From: Liz Annalls [REDACTED]
Sent: 10 February 2020 14:51
To: Planning.Responses <Planning.Responses@arun.gov.uk>
Subject: RE: Planning Consultation on: FG/8/20/PL

App No: FG/8/20/PL

Address: Eastlands Littlehampton Road Ferring BN12 6PB

Proposal: Erection of 1 No. equestrian dwelling & retention of 1 No. gazebo & 2 No. carports. This application is a Departure from the Development Plan & may affect a Public Right of Way.

Title:
Proposed Dwelling

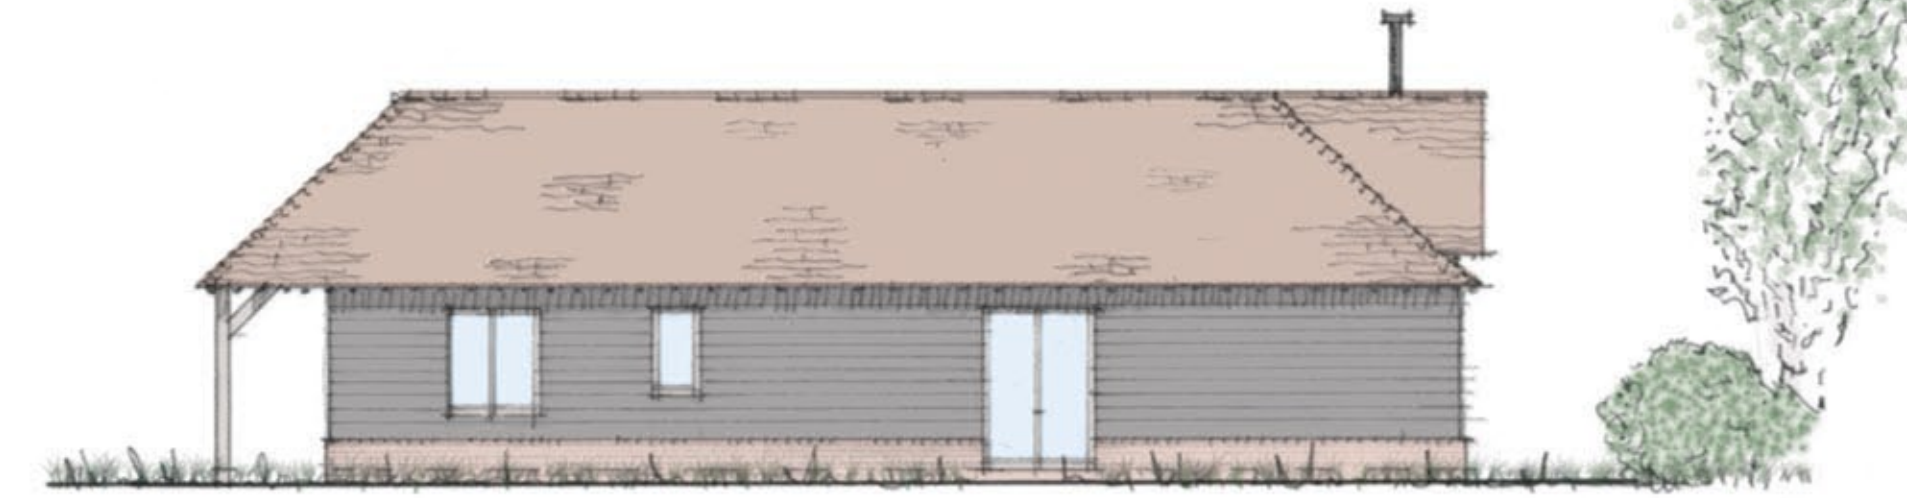
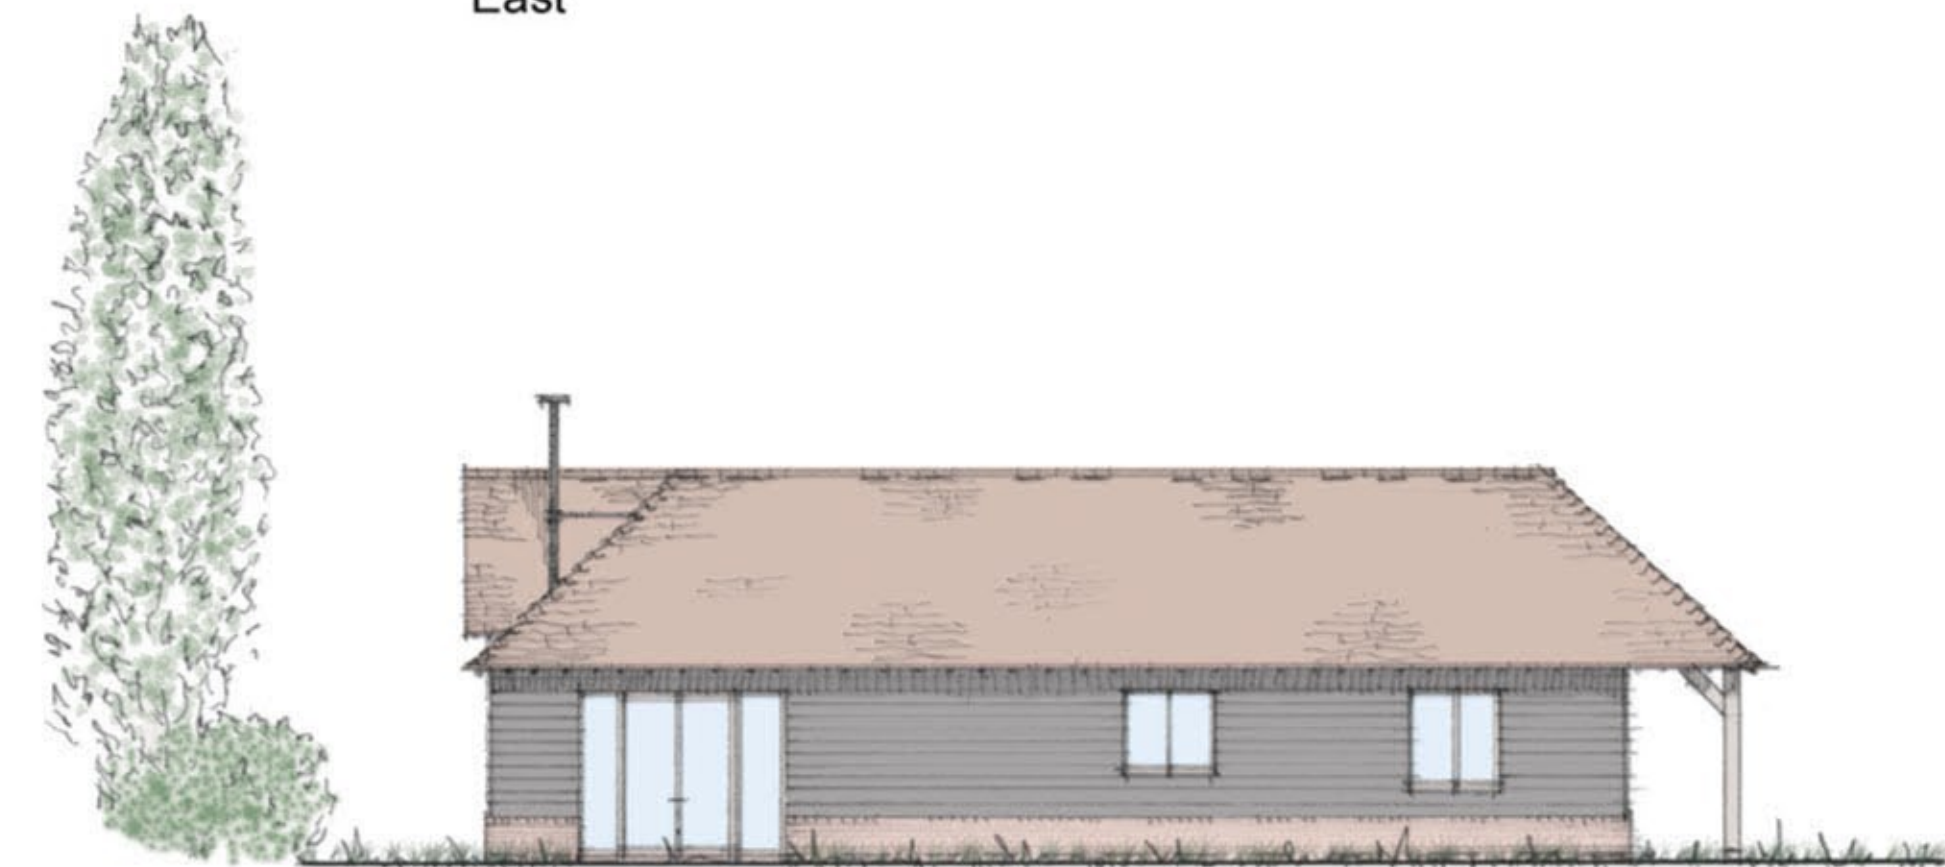
We require that a bat brick is integrated into the building onsite facing south/south westerly positioned 3-5m above ground.

We would like a bird box to be installed on the building / and or tree within the grounds of the property.

Title:
Proposed Site Plan

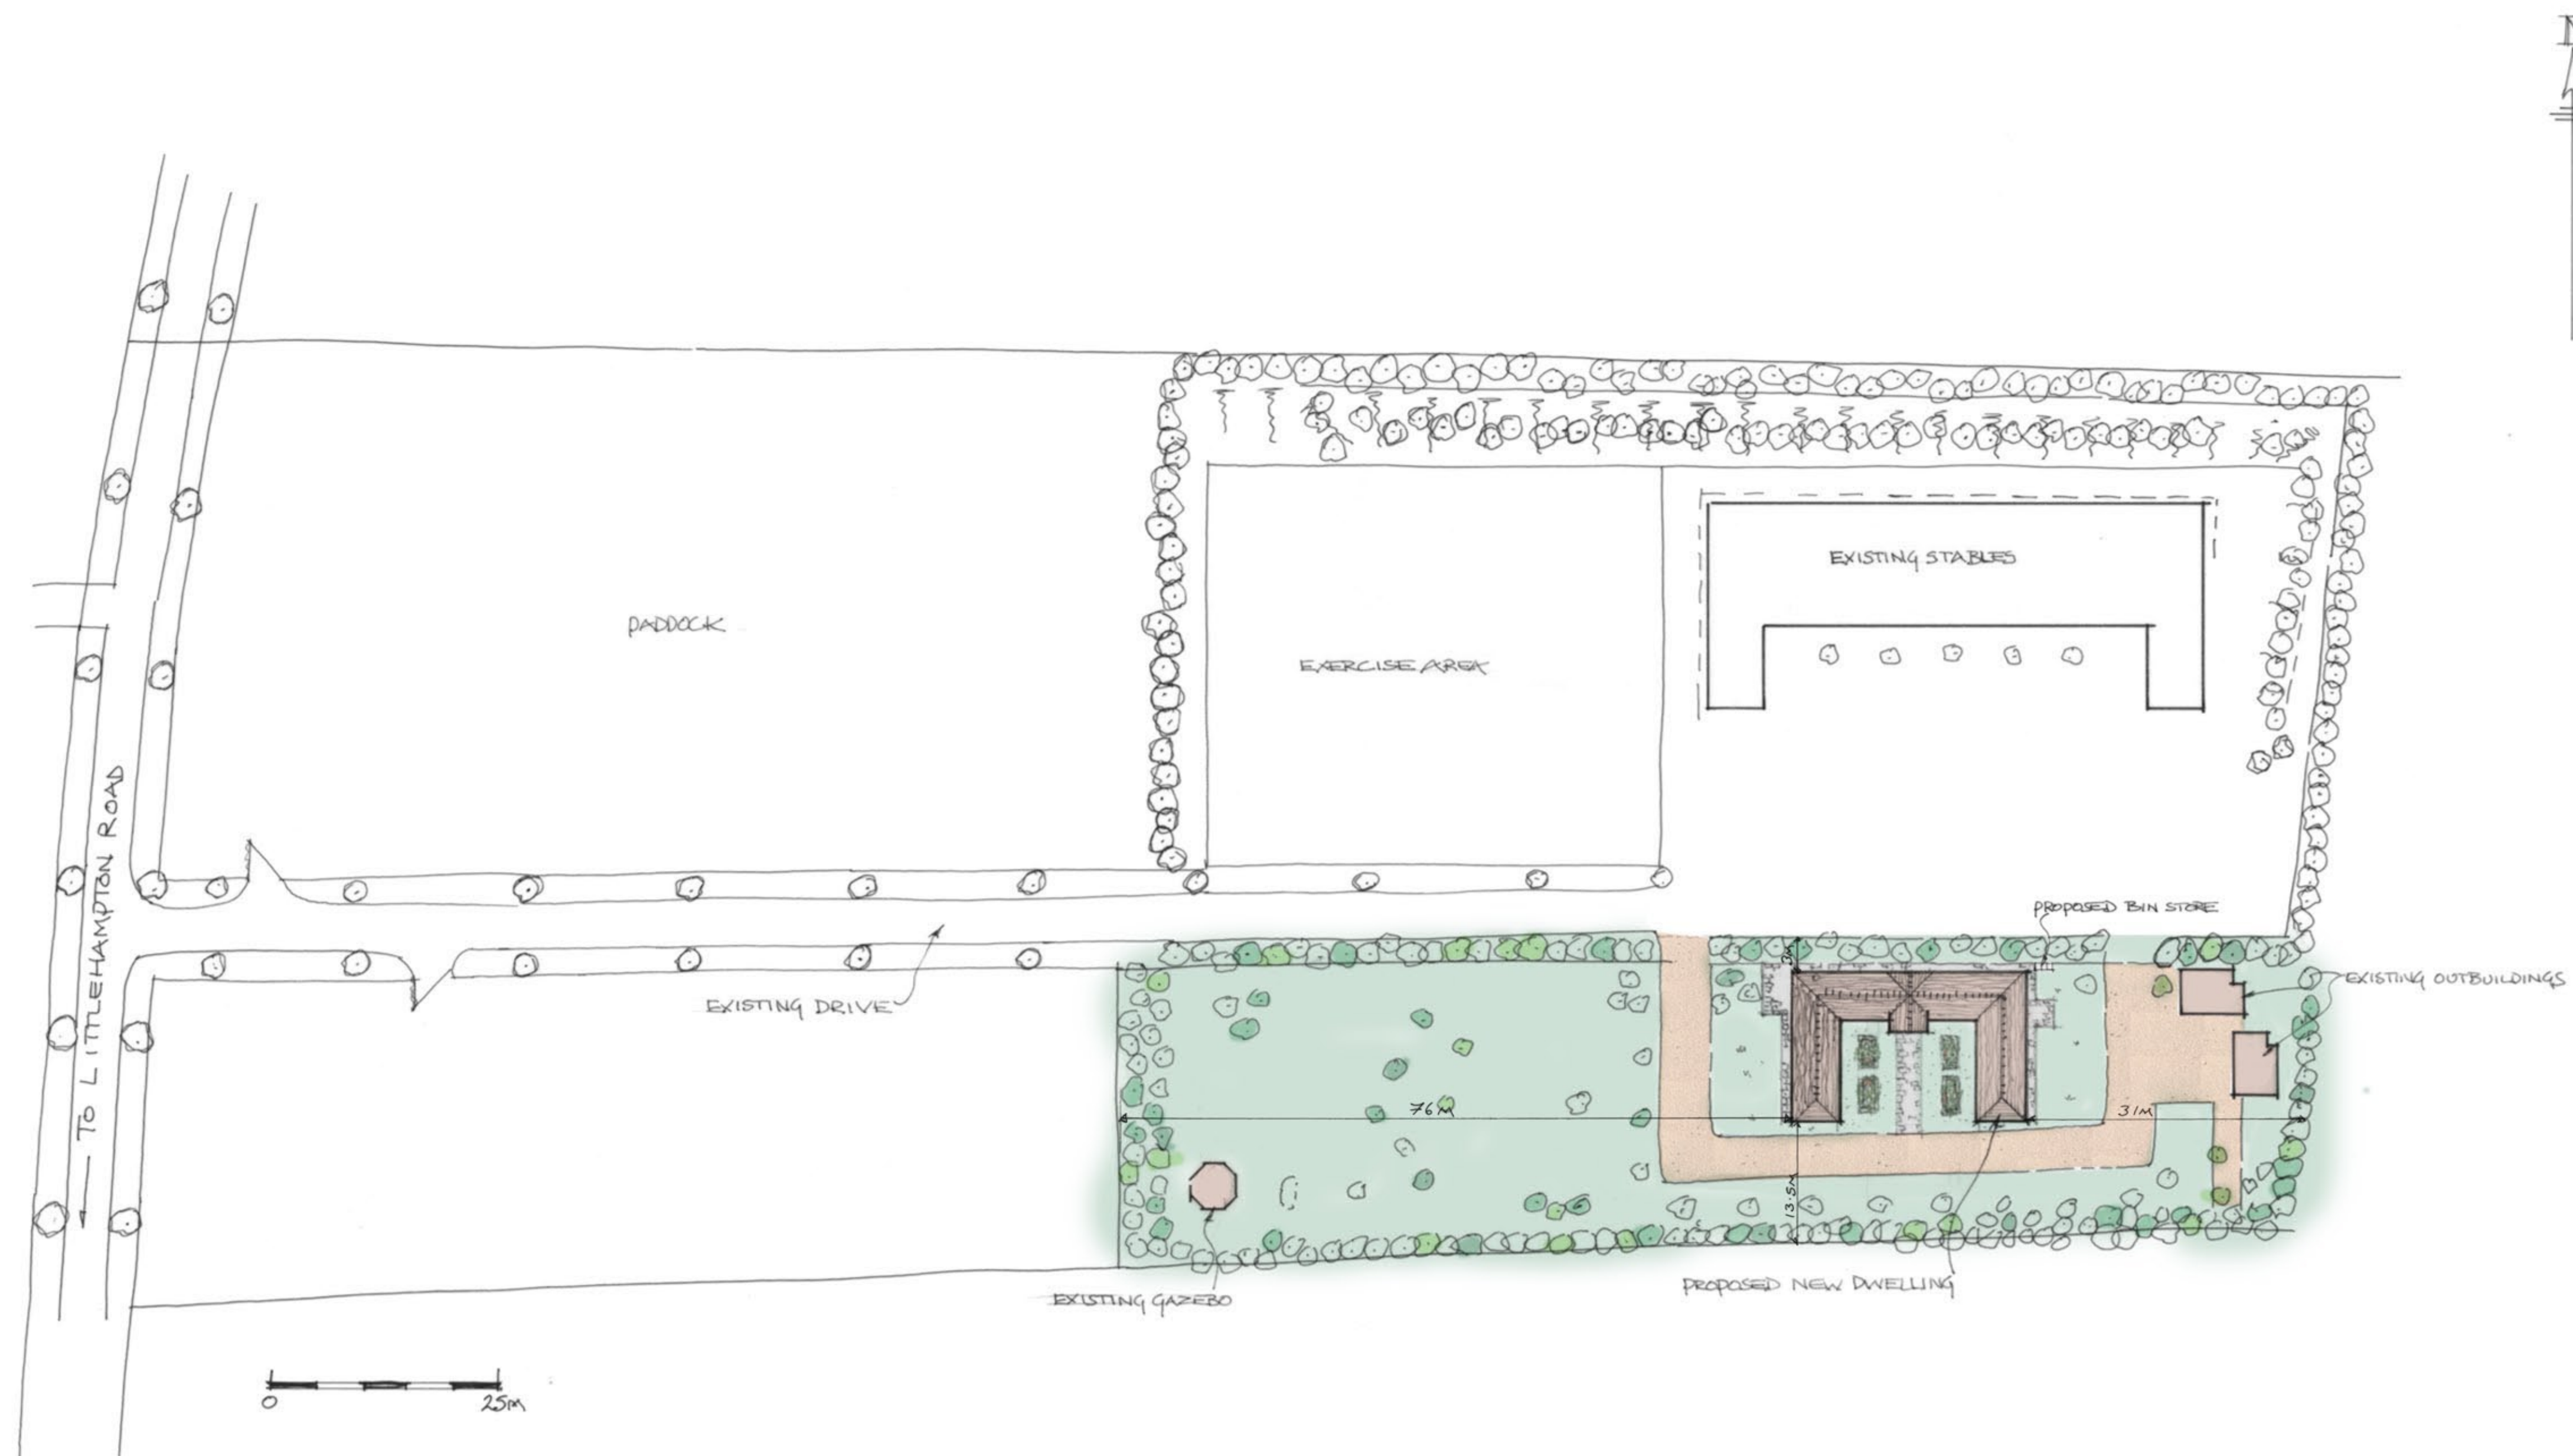
The hedgerows on site are used by bats for commuting and foraging and will need to be retained and enhanced for bats. This will include having a buffer strip around the hedgerows and during construction fencing should be used to ensure this area is undisturbed. Any gaps should also be filled in using native hedge species to improve connectivity. Conditions should be used to ensure this.
